GREATER LONDON AUTHORITY

Deadline 3 - GLA Sheet 2: GLA Commentary on Applicant's response to ExA's first Written Questions

Figure 7.5 Rev 01

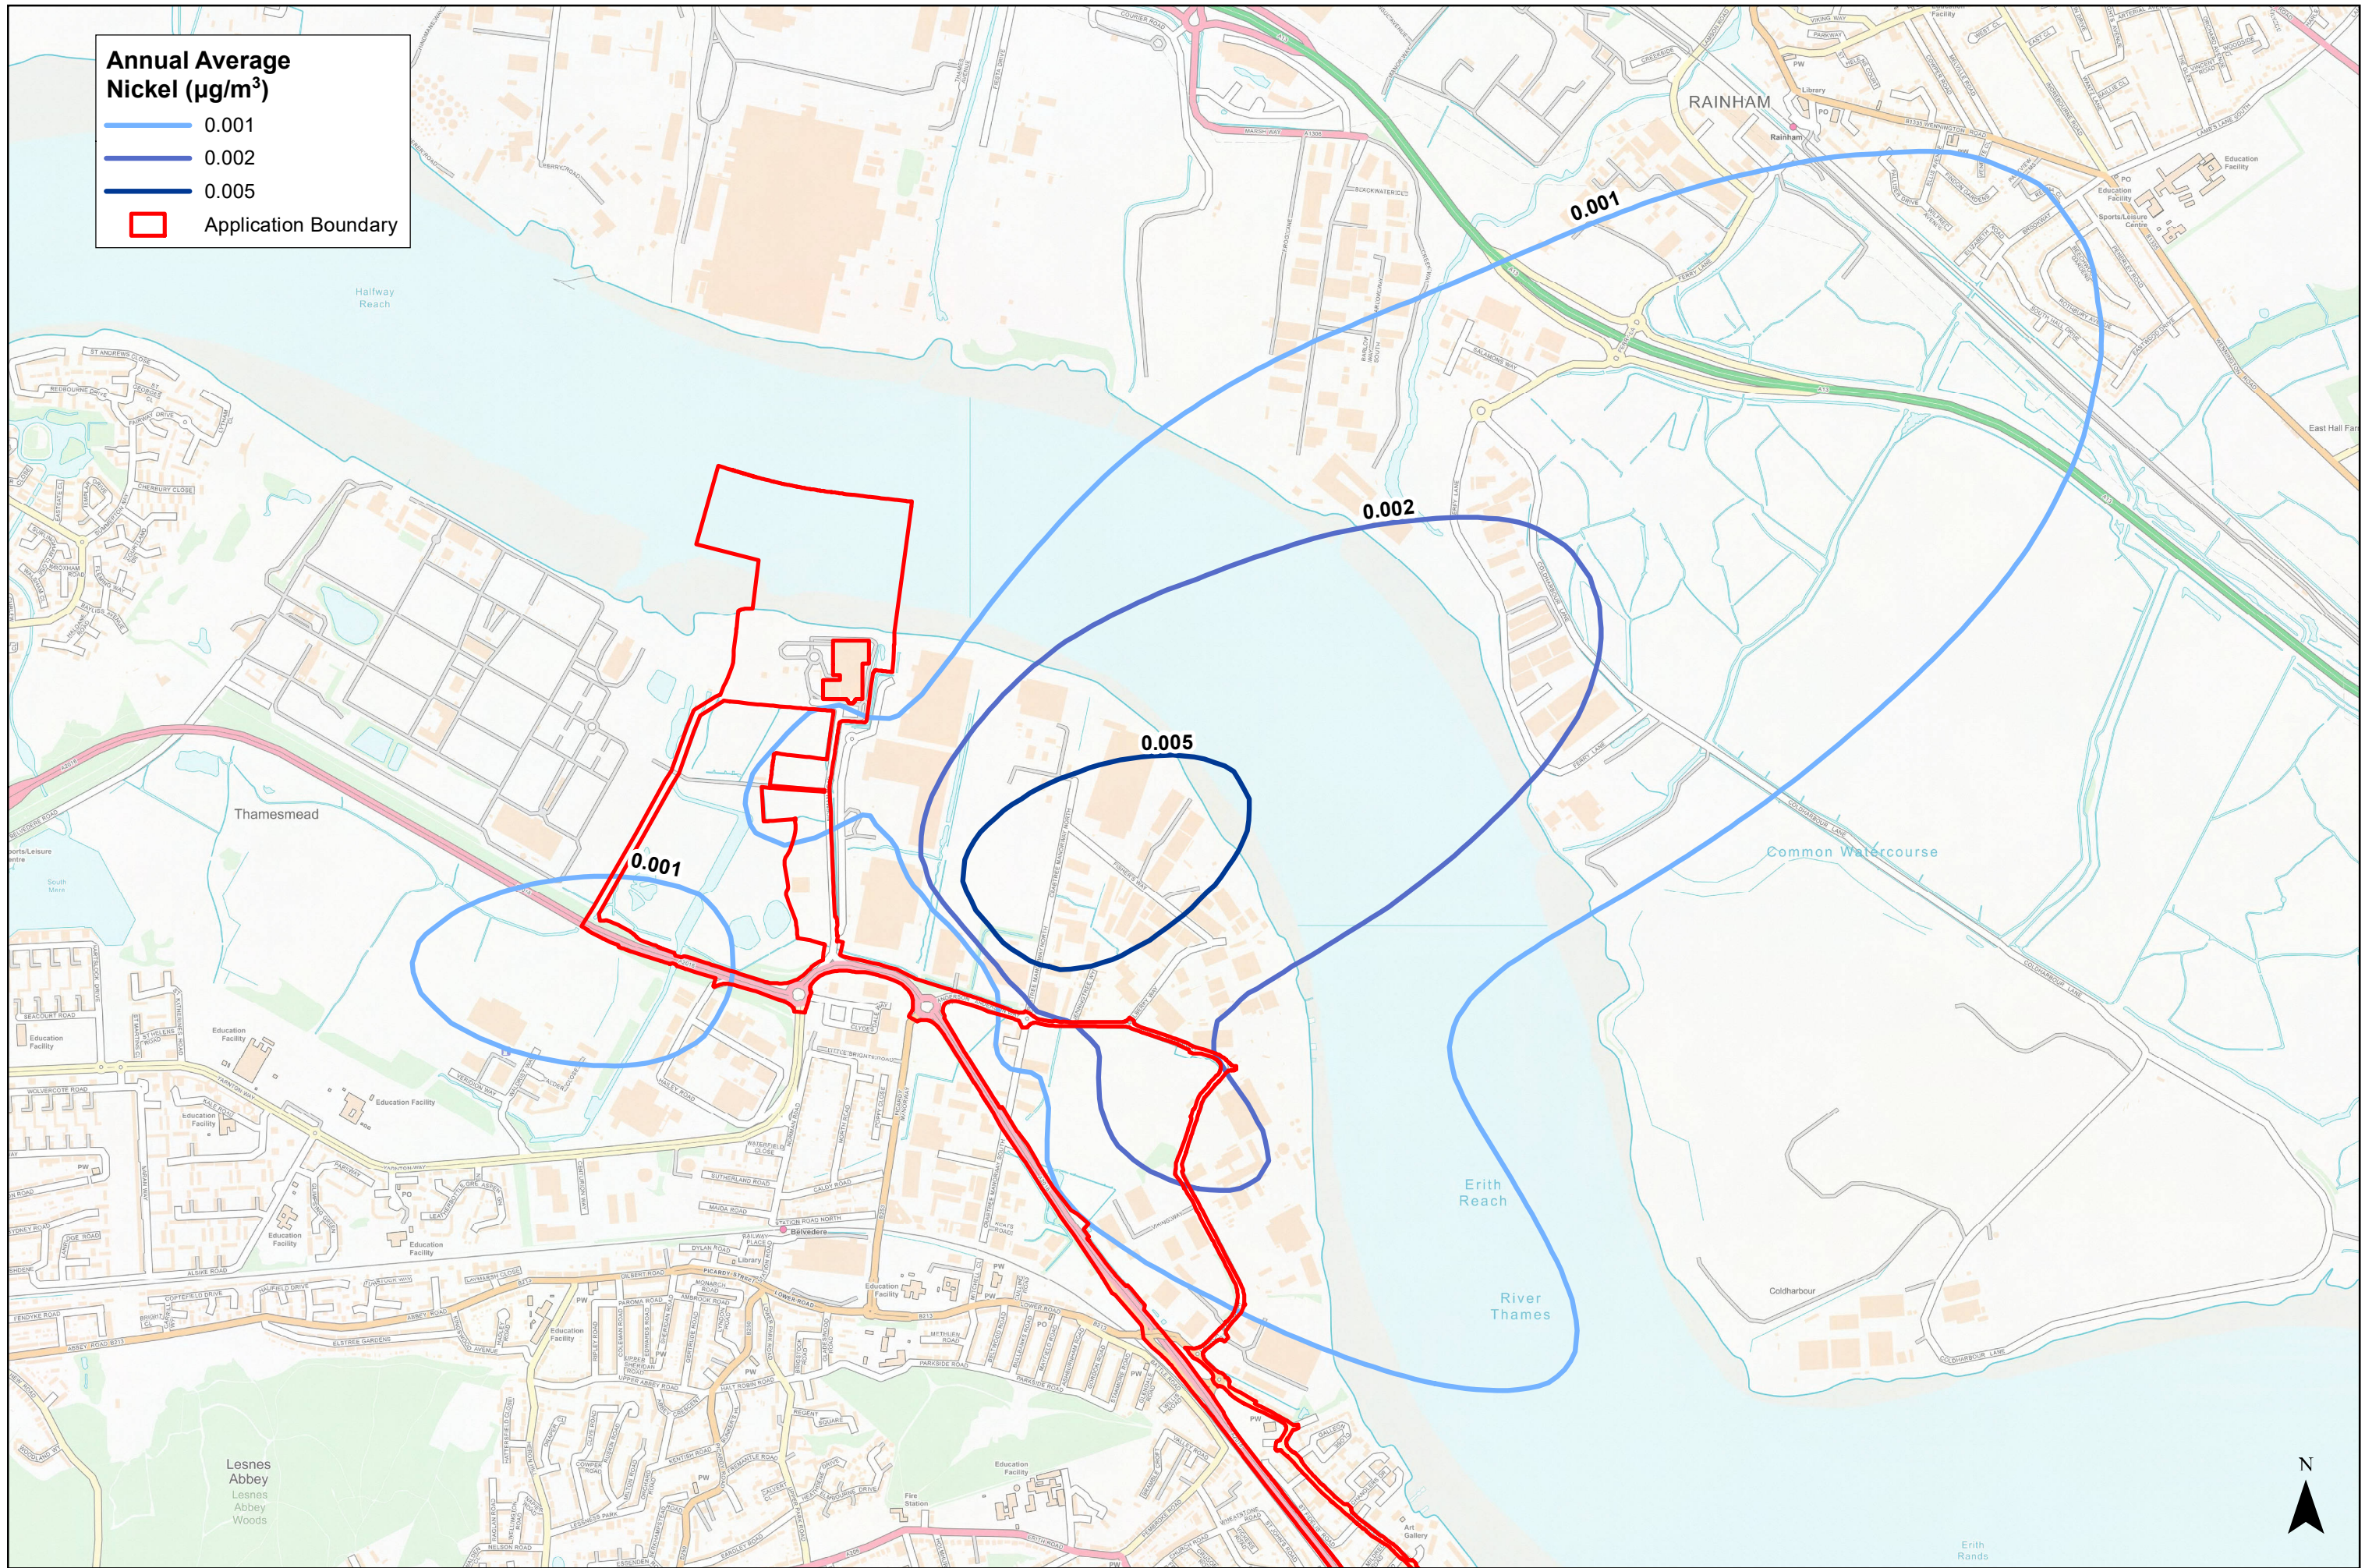
ExA Q	ExA Question	Applicant's Response	GLA/TFL Comments
	<p>C2.2.8 in Appendix C2 reports a Minor impact due to predicted annual average nickel concentrations at 7 receptors. Although 2 are within a business park, the remaining 5 are residential areas. The Applicant states that this is not significant. However, it should be noted that at paragraph 7.5.62 (methodology) the Applicant has stated that according to IAQM guidance the assessment of significance should be based on professional judgement taking into</p>	<p>illustrated by receptor R22) have negligible impacts which would be the majority of the exposed population in Rainham. As the majority of the population exposure is negligible and the maximum level of exposure is minor, and in particular, there are no breaches of assessment levels with the maximum Predicted Environmental Concentrations (PECs) well below (less than 25%) of the assessment level, then the overall significance is judged to be negligible, which is a not significant effect. The rationale is summarised in Paragraph 7.9.30 of Chapter 7 Air Quality of the ES, (6.1 Rev 1).</p>

ExA Q	ExA Question	Applicant's Response	GLA/TFL Comments
	account several factors, including the number of properties affected. This information has not been found in the ES. Can the Applicant explain how the IAQM guidance has been applied to determine the significance of the identified minor effects at Table C2.2.8?"
